# CITY OF ALBUQUERQUE

July 20, 2016

**Re: Clean Machine Carwash**  
**4200 San Mateo Blvd., NE**  
**Traffic Circulation Layout**  
Engineer's/Architect's Stamp **6-9-16** (G18-D049)

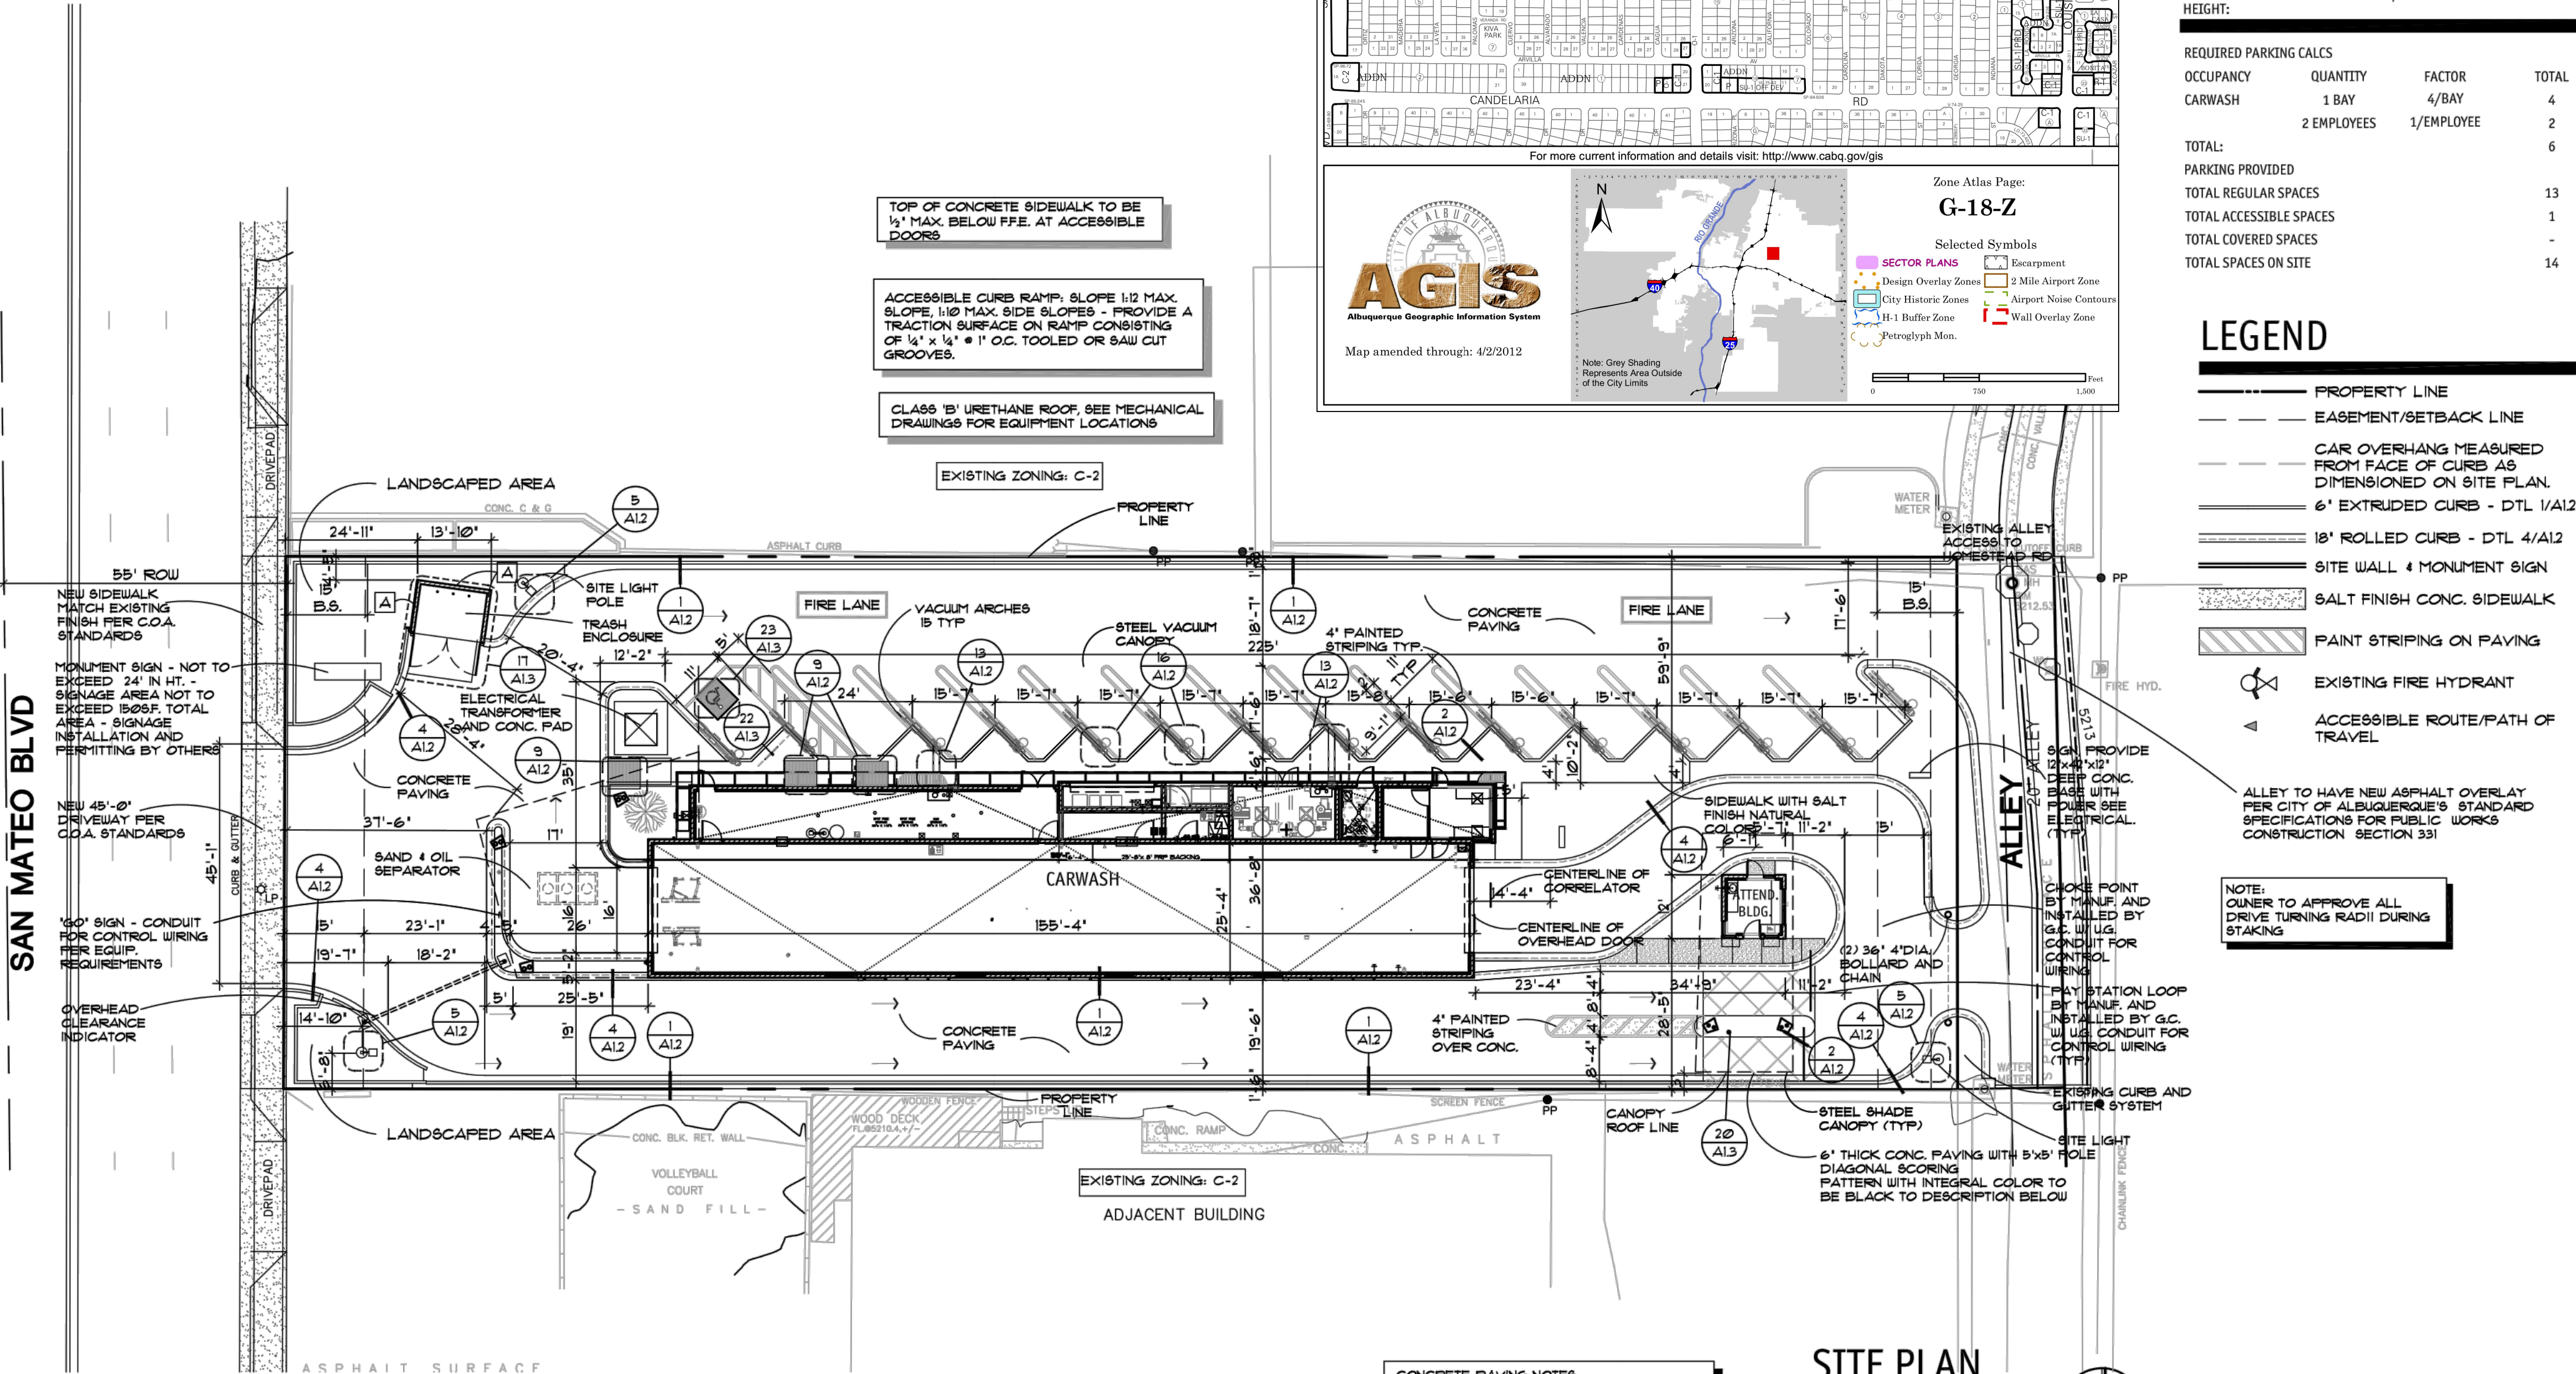
1. Please provide the Detail Sheets labeled on the TCL submittal.
2. Clarify circulation of vehicles at the main entrance on San Mateo Blvd. There appears to be conflicting vehicle movements. Please add detail of directional arrows and signage.

3. The curb cut on San Mateo should be a maximum of 40 ft. wide.
4. Please identify and dimension all proposed, doors, structures, sidewalks, curbs, drive pads, ADA ramps, walls and anything that influences the parking and circulation on the site.

5. Identify the right of way width, medians, curb cuts, and street widths on San Mateo Blvd.
6. Detail and dimension bicycle and motor cycling parking spaces, along with appropriate signage.

7. Dimension the length of the handicap accessible space.
8. The ADA accessible parking sign must have the required language per 66-7-352.4C NMSA 1978 **"Violators Are Subject to a Fine and/or Towing."** Please call out detail and location of HC signs.

9. Per DPM, a 6 ft. wide ADA accessible pedestrian pathway is required from the public sidewalk to the building entrances. Please clearly show this pathway and provide details of ramps from ROW.

10. Provide a min 6" or max 8" high concrete barrier curb or other acceptable barrier between landscaping and parking areas and/or drive aisles. Please call out detail and location of barrier curb. Please call out this detail.

11. One-way vehicular paths require pavement directional signage and a posted **"Do Not Enter"** sign at the point of egress. Please show detail and location of posted signs.

12. Please specify the City Standard Drawing Number when applicable.
13. Please add a note on the plan stating "All improvements located in the Right of Way must be included on the work order."
14. Please include two copies of the traffic circulation layout at the next submittal.
